From: Amber Willard
Sent: 15 April 2019 10:48
To: Planning.Responses
Subject: FW: FP/46/19/PL
Attachments: APL 05.3 plans.pdf; APL 06.3 roof plan and sections.pdf

From: Amber Willard [REDACTED]
Sent: 12 April 2019 16:28
To: Ray Bell [REDACTED]
Subject: FP/46/19/PL

I am the case officer on your application FP/46/19/PL at 28 Sea Drive.

Revised: Revision Description: HSA No:
APL 06.3 Z0388

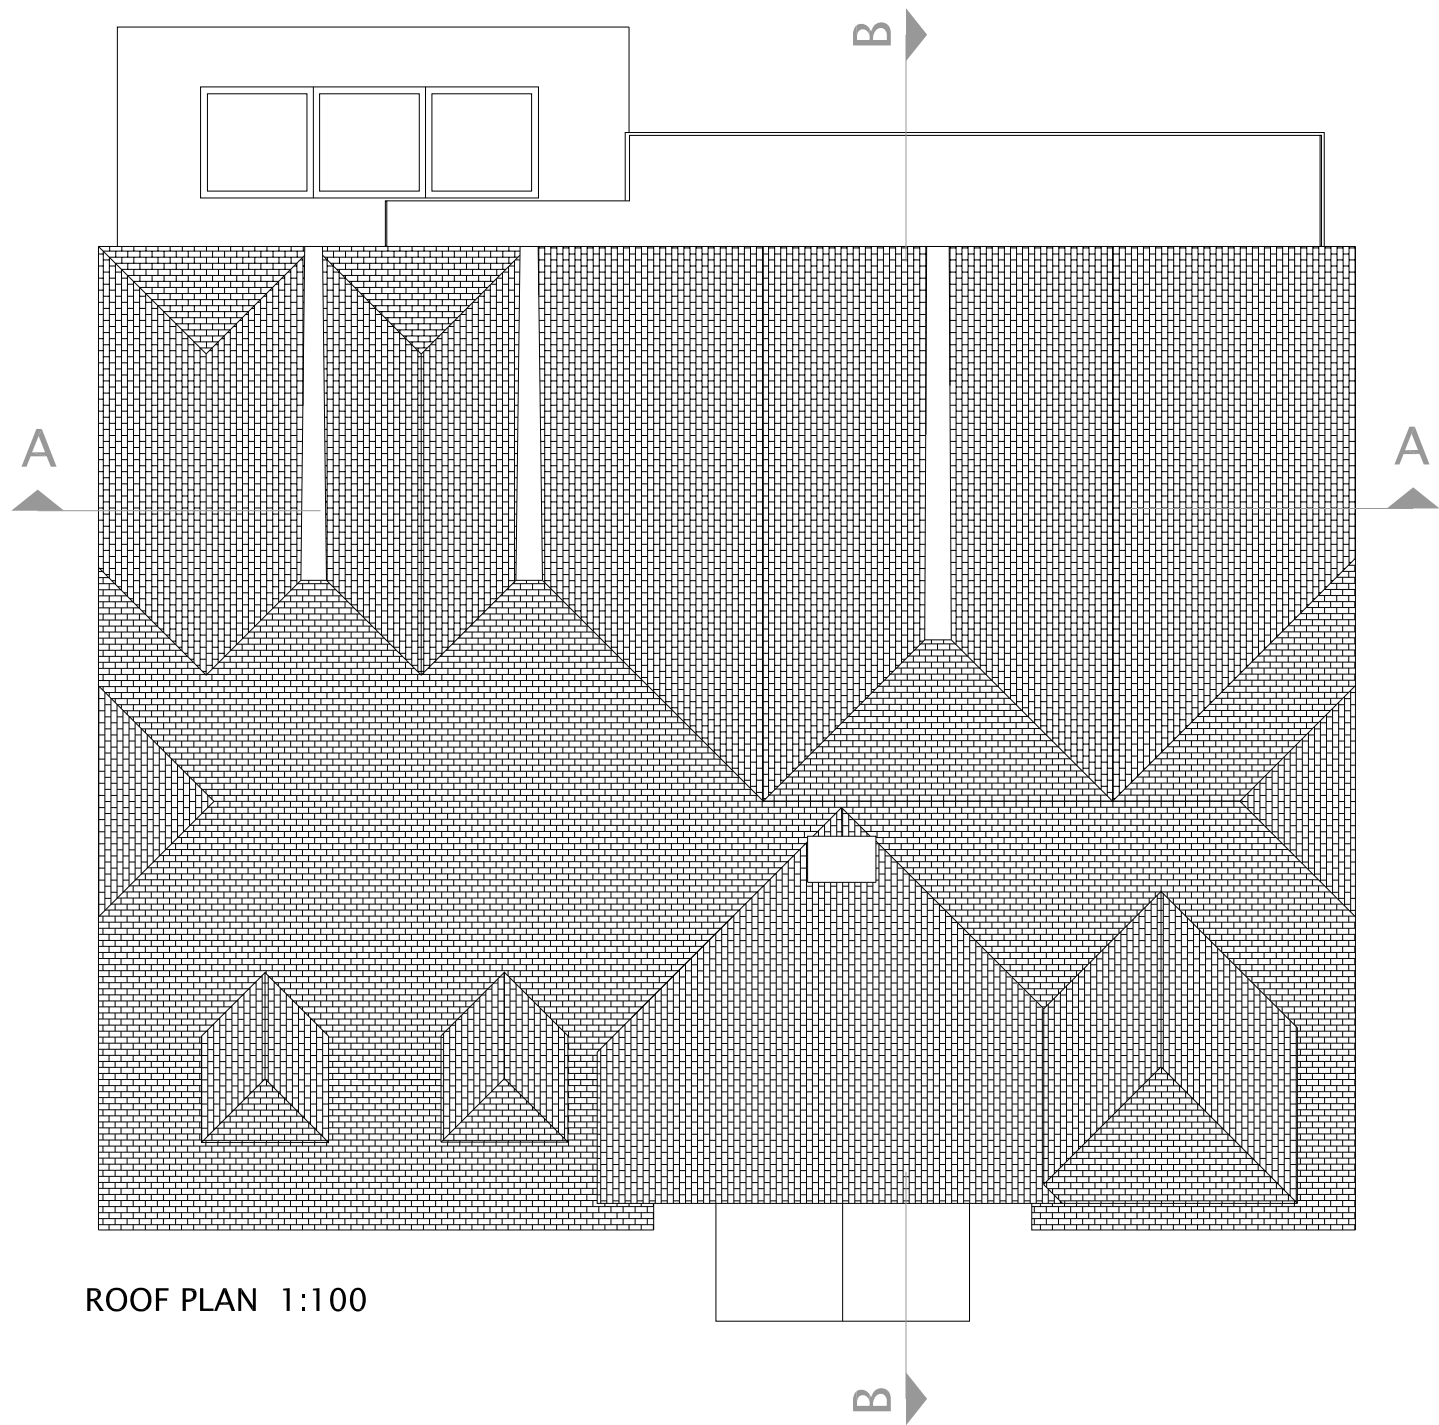
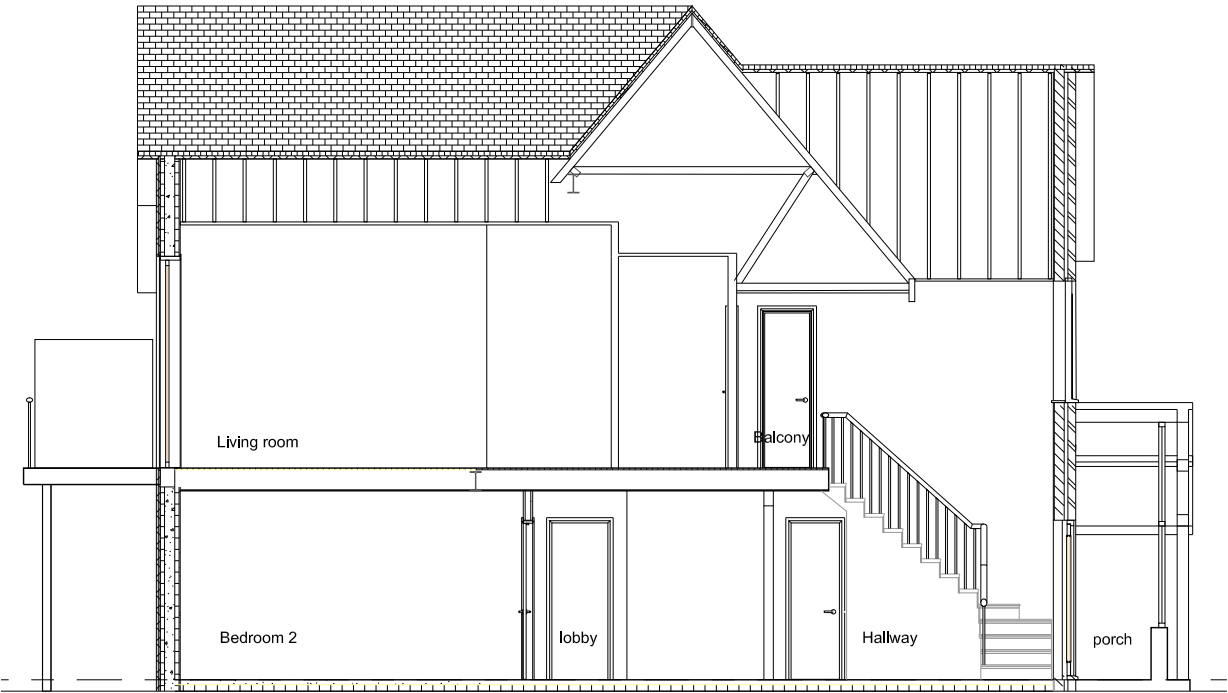
However on the proposed elevations ,roof and floor plan the balcony appears to have been extended towards the east and only retains around 1.3m

My apologies, I inadvertently sent out-of-date plans. The attached drawings APL 05.3 and APL 06.3 show the correct layout.
